REF.: DRAINAGE REPORT FOR THE WAL-MART SITE AT
COORS & RIO BRAVO BOULEVARD

The District has reviewed the grading and drainage plan for the above referenced. The following comments must be addressed prior to construction:

Re: Wal-Mart South Drainage Report
Engineer Stamp date 2-25-04 (P10/D4)

POND 9
BEGIN 8" PVC
W/ 1/2" ORIFICE PLATE
W/ STAND PIPE

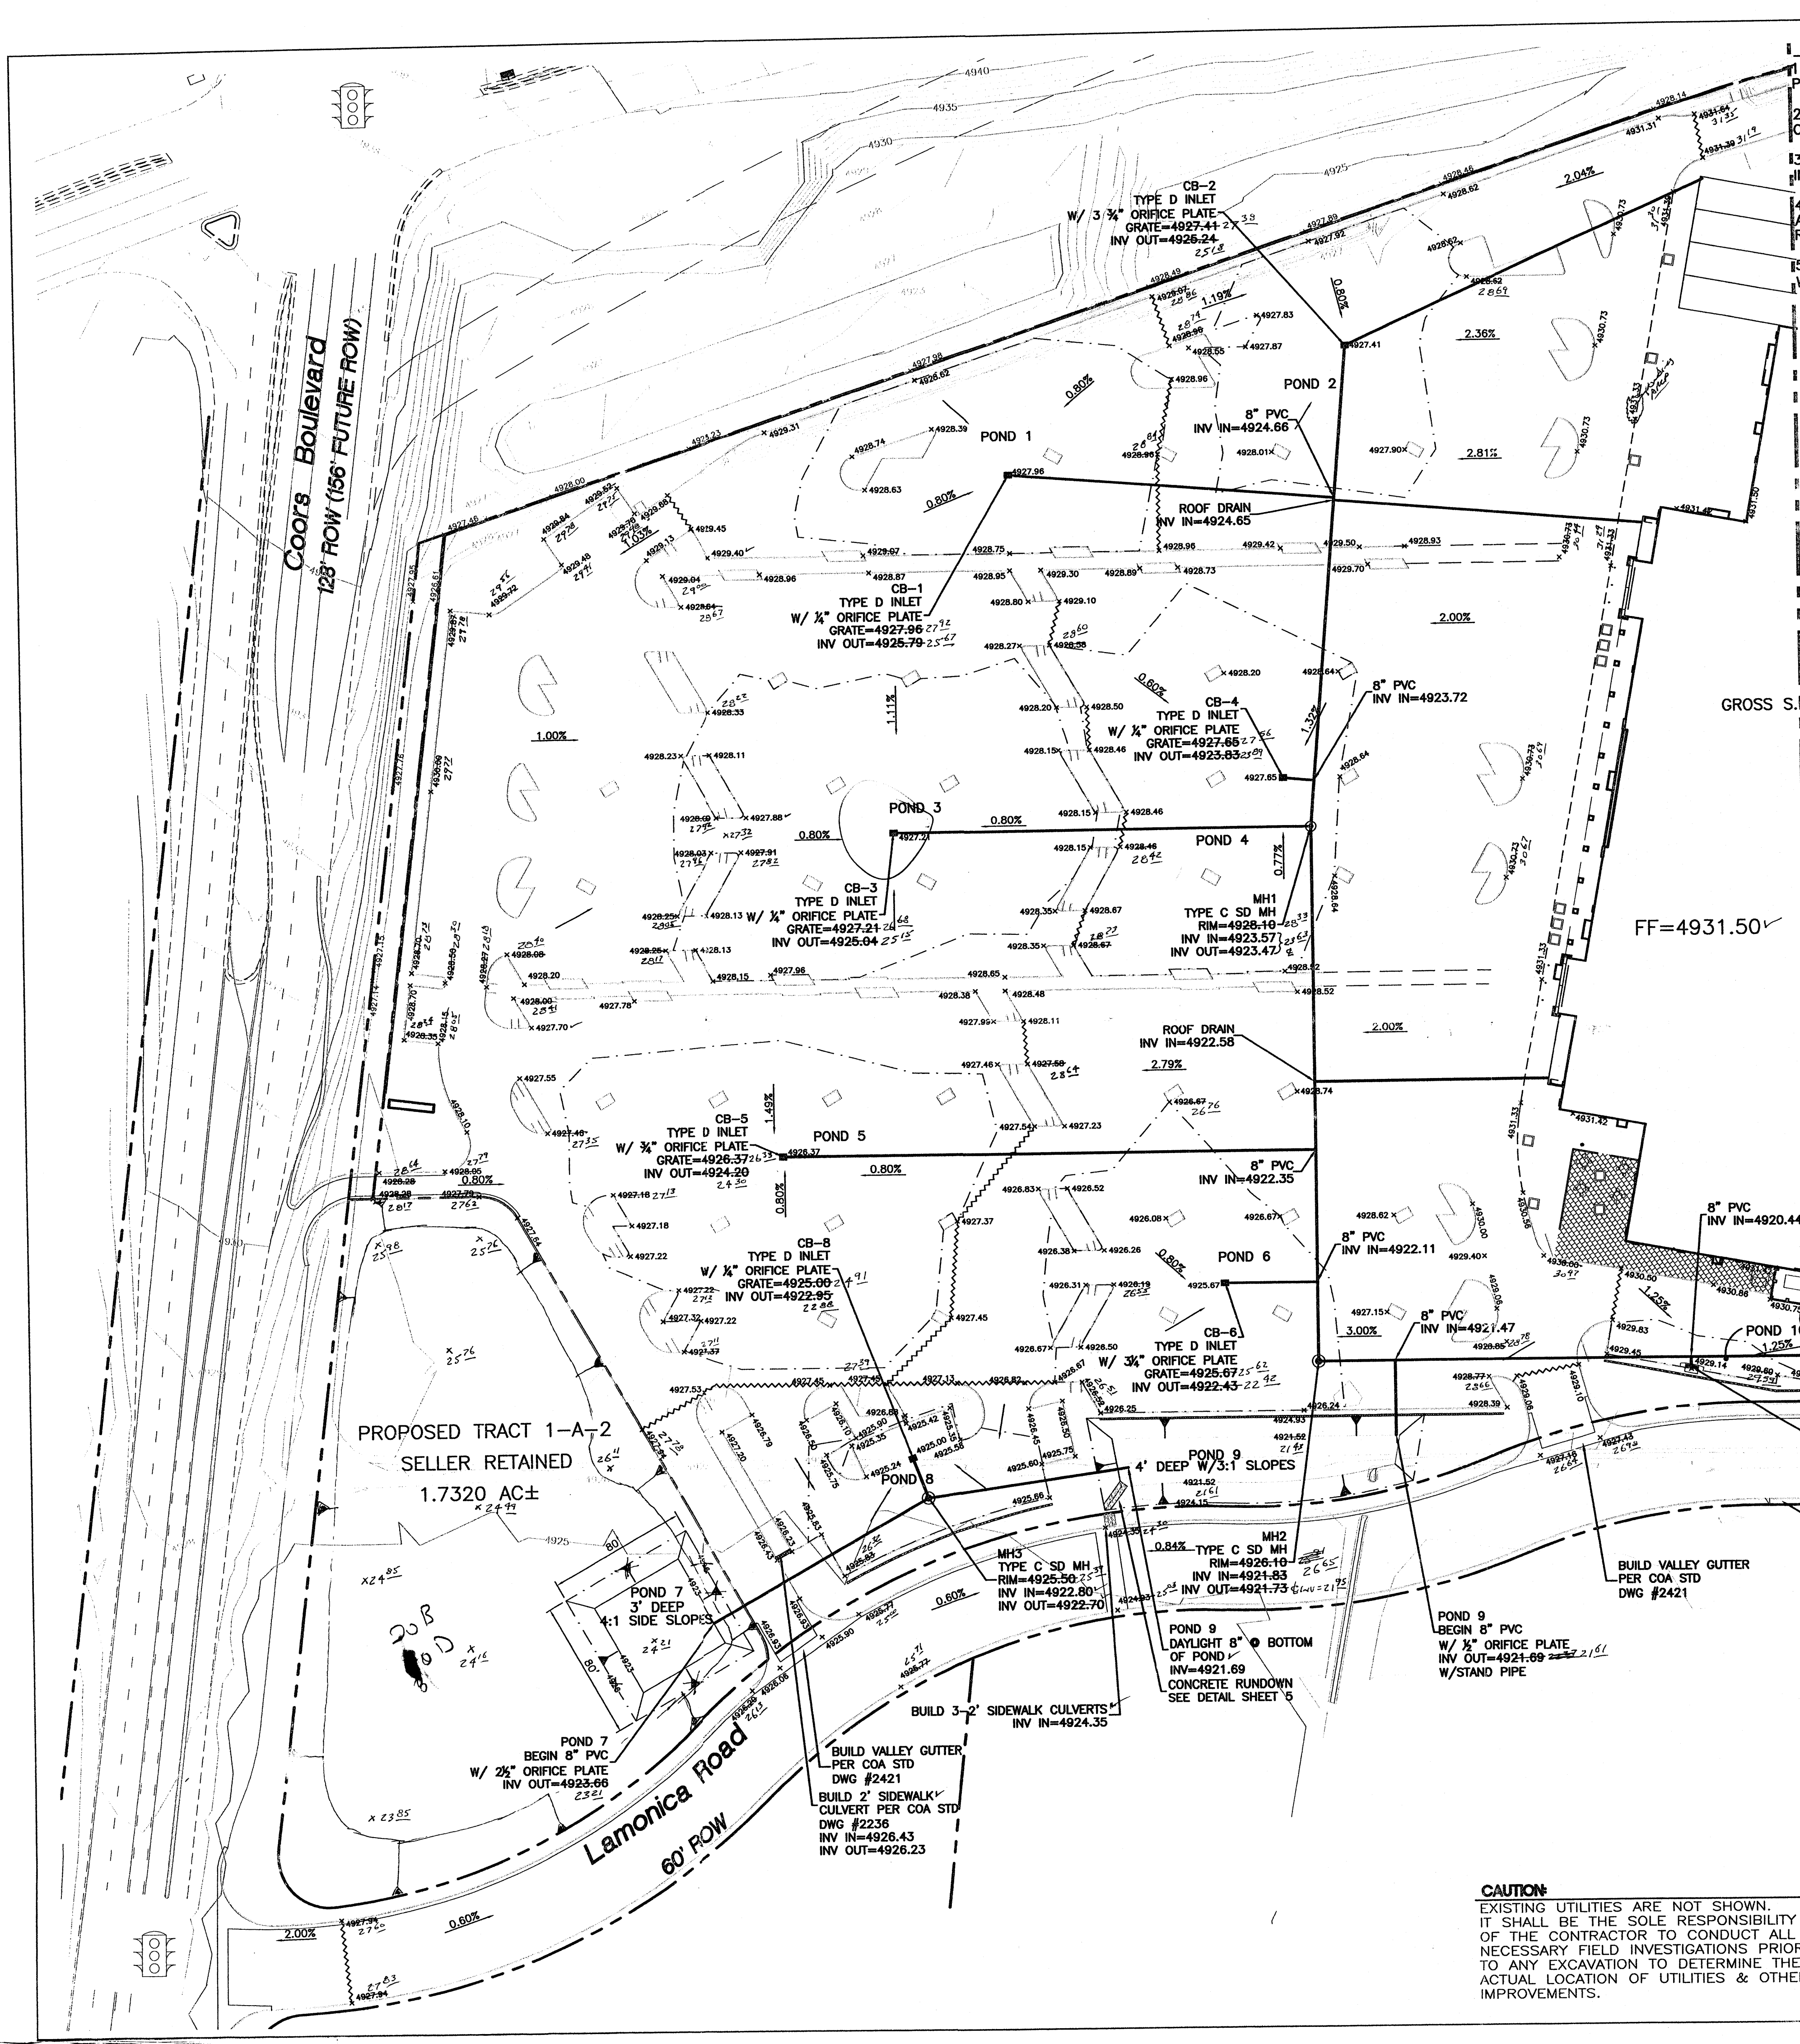
- Please provide written concurrence from MRGCD for the connection to the Isleta Drain. The plan should show the improvements for the channel even though it will be built by Work Order.
- A 0.25" diameter orifice will be incredibly hard to keep from getting clogged. I think these particular inlets should have a detail for removing debris away from the orifice.
- Since the plat is already filed and some of your ponds are accepting public water from the streets, public easements must be provided and an agreement and covenant will be necessary. Since your client is an out-of-town corporation, I would be willing to make this a condition of Certificate of Occupancy but please begin this process as soon as possible.
- Ponds 9, 15 and 19 must have a standpipe outlet with an overflow weir.

TITLE: **WAL-MART #5430-00**
DRAIN IMPROVEMENTS
ISLETA DRAIN

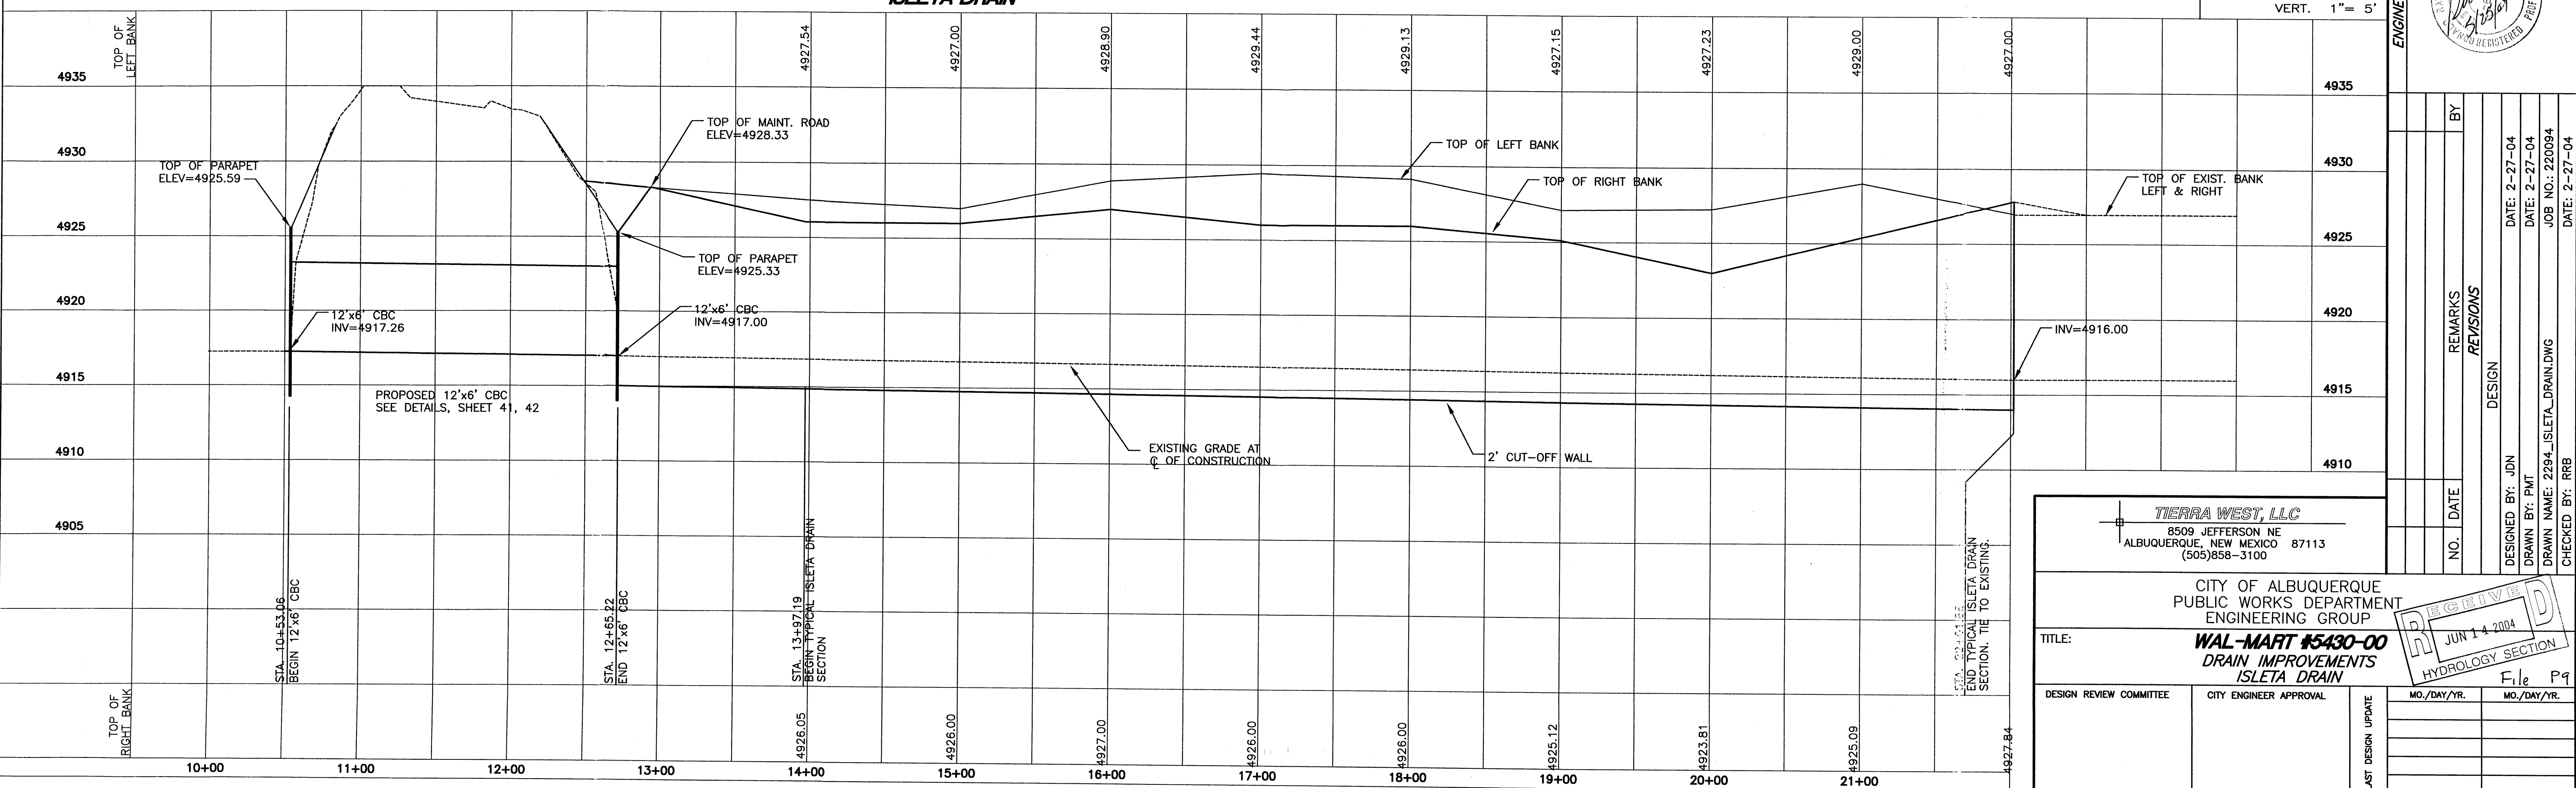
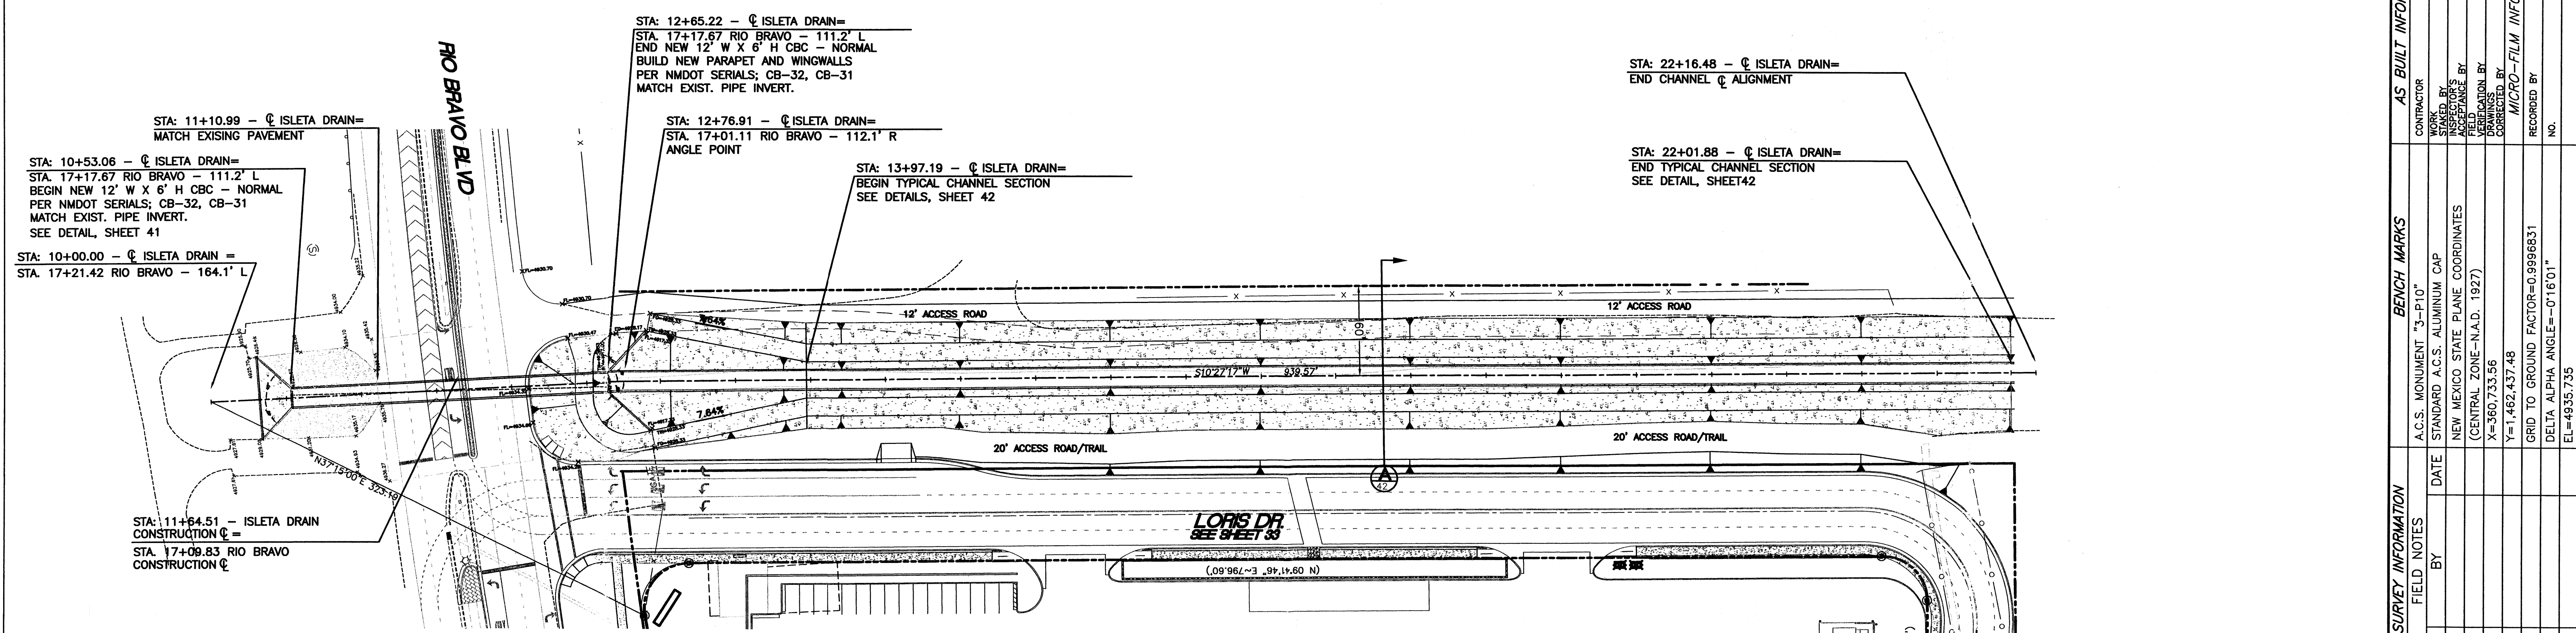
1. The District may consider a license to discharge storm water at a rate not to exceed 5 cfs if the Isleta Drain is improved per specifications by AMAFCA & MRGCD under the new drainage study to be completed by AMAFCA & Bernalillo County. Construction plans are required for review and comment.
2. A water quality improvement structure is proposed on the Wal-Mart site prior to discharging into the Isleta Drain. Provide the manufactures information for maintenance of the structure and information for sizing.
3. Who will be responsible for maintaining the water quality structure?
4. A license to replace the existing Rio Bravo Boulevard road culvert crossing is required. Construction plans are required for review and comment.
5. Your plans show the encroachment of a portion of Loris Drive within the Isleta Drain Right-of-Way. A license will be required to allow the encroachment.

The channel will be designed and constructed based on comments received at the June 17, 2004 meeting with all agencies in attendance. Approval of the plans will be required by AMAFCA and MRGCD prior to the City of Albuquerque issuing a work order for the project.
